Development Control
Arun District Council
re: Application No A/112/12
The Lamb Inn, Angmering

Application for Decking Area to rear of Lamb Public House

PROPOSED BLOCK 1:200

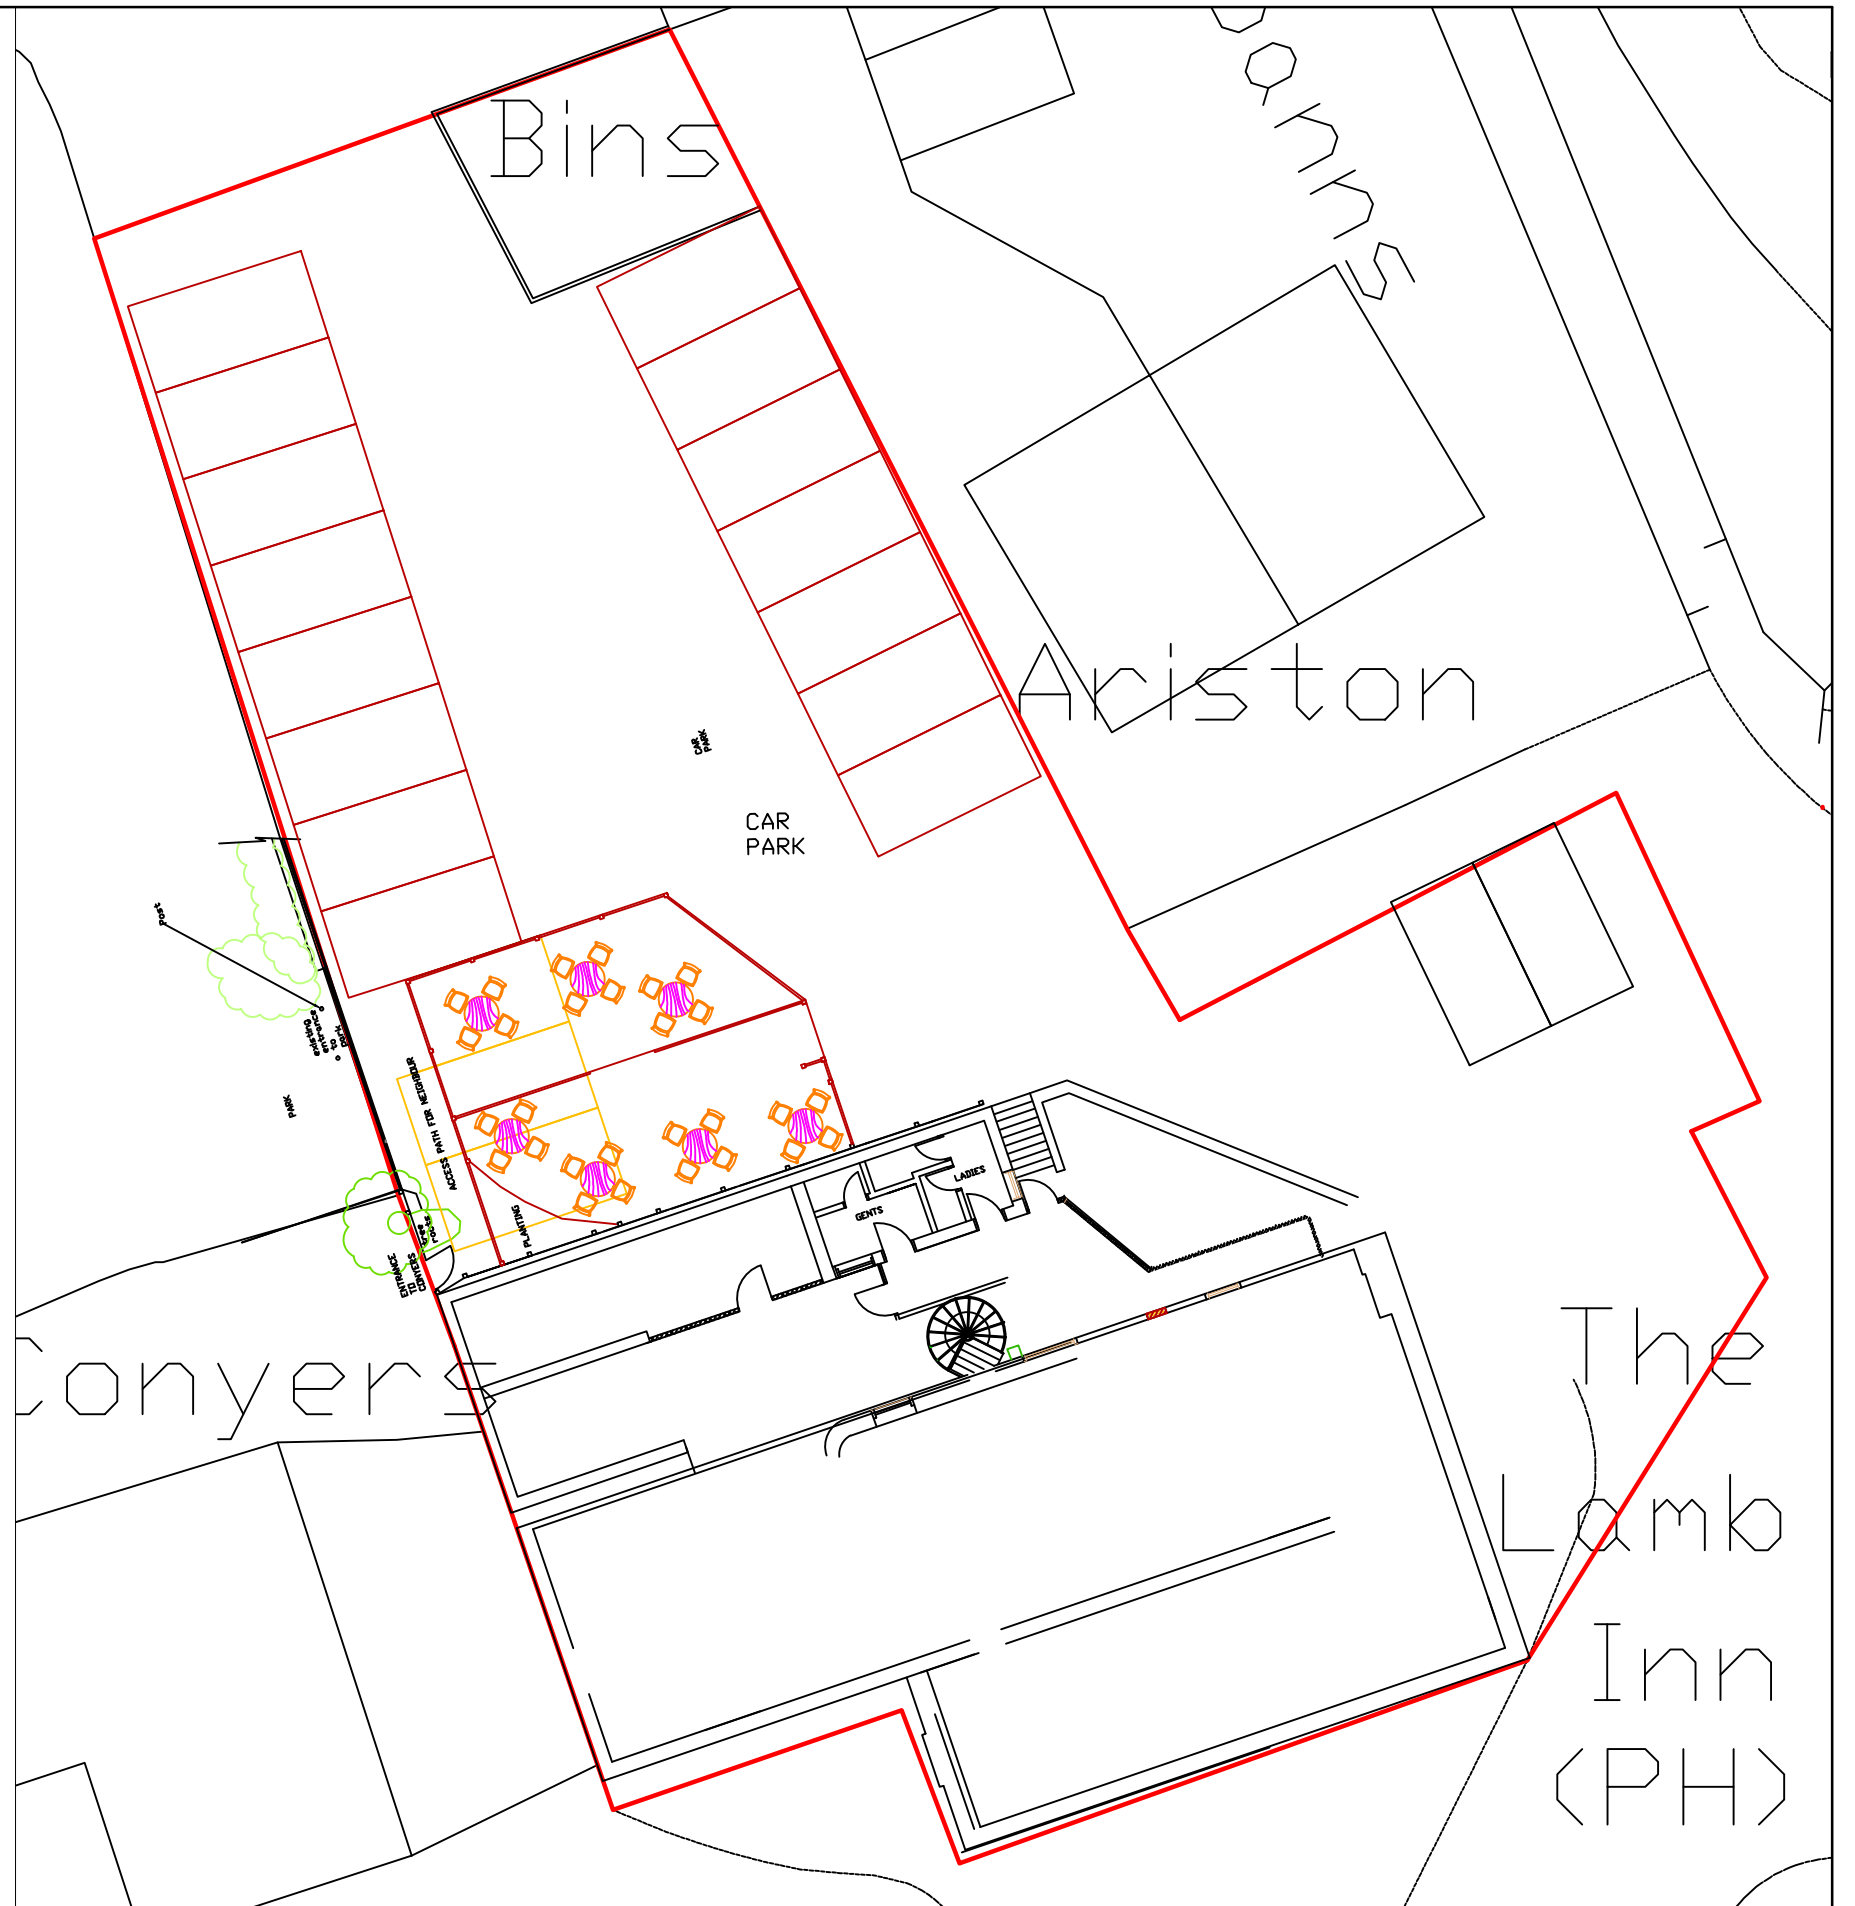
- 1) It is likely that there will be increased noise pollution into St Nicholas Gardens, which are to the rear of our property.
- 2) Will sufficient vehicular access be made to St Nicholas Gardens to enable it to be properly maintained, particularly for regular grass cutting and care of shrubs and trees?
